Planning Officer: Michael Eastham

Planning Application Ref: AB/135/20/OUT

Location: Land at Ford Road, Arundel

Description of works: Outline application with some matters reserved (except for access) for the development of 90 dwellings & associated amenity land. This application is a Departure from the Development Plan, affects the setting of listed buildings & affects the character & appearance of the Arundel Conservation Area

Illustrative Masterplan

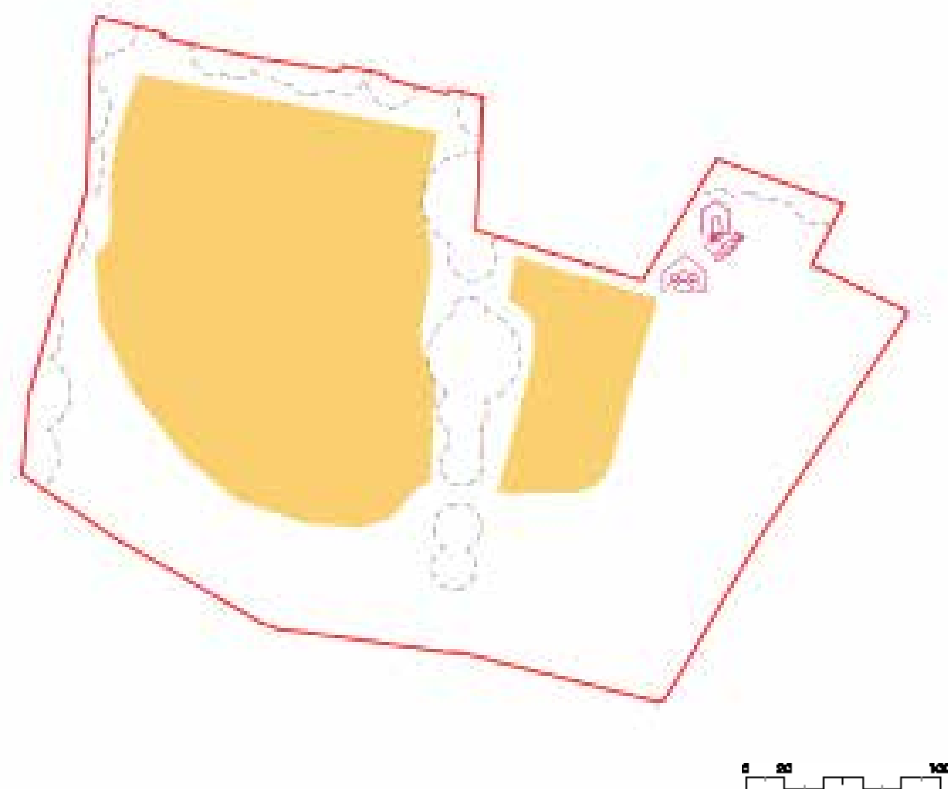
- In respect of dwg. IM003 Rev. 1, I make the following comments:
 - The interior arterial road which bisects the established tree line has been carefully positioned to minimise landscape impact.

- I see no obvious major problem with the proposed location of dwellings and the majority of associated infrastructure, nor vehicle access onto Ford Road, although I am disappointed not to see 2m buffer zones beyond the root protection area (RPA) of significant trees incorporated into the layout. This will need to be addressed and can be done so without impacting heavily on unit size and quantity.

- Areas identified for essential refinement:
 1. T10 & T11 - 2m buffer required at W aspect of RPAs
 2. T13 - No overriding justification for RPA incursion. 2m buffer required at W aspect of RPA

3. T76 - No overriding justification for RPA incursion. 2m buffer required at S & W aspects of RPAs
 4. T66 & T71 - No overriding justification for RPA incursion. 2m buffer required at S aspect of RPAs

5. T58 - 2m buffer required at E aspect of RPA
 6. T55 & T56 – TPF to be re-positioned, fully respecting RPA +2m buffer zone on E aspects.
 - In respect of any soft-landscape proposals, I defer to our Leisure and Landscape Officer, although I would encourage the selection of native tree species of potential stature (>15m ht.) and longevity such that they will grow to enhance the local landscape, ultimately compensating for the proposed removal and foreseeable decline of individual trees and groups/hedgerow across the site.
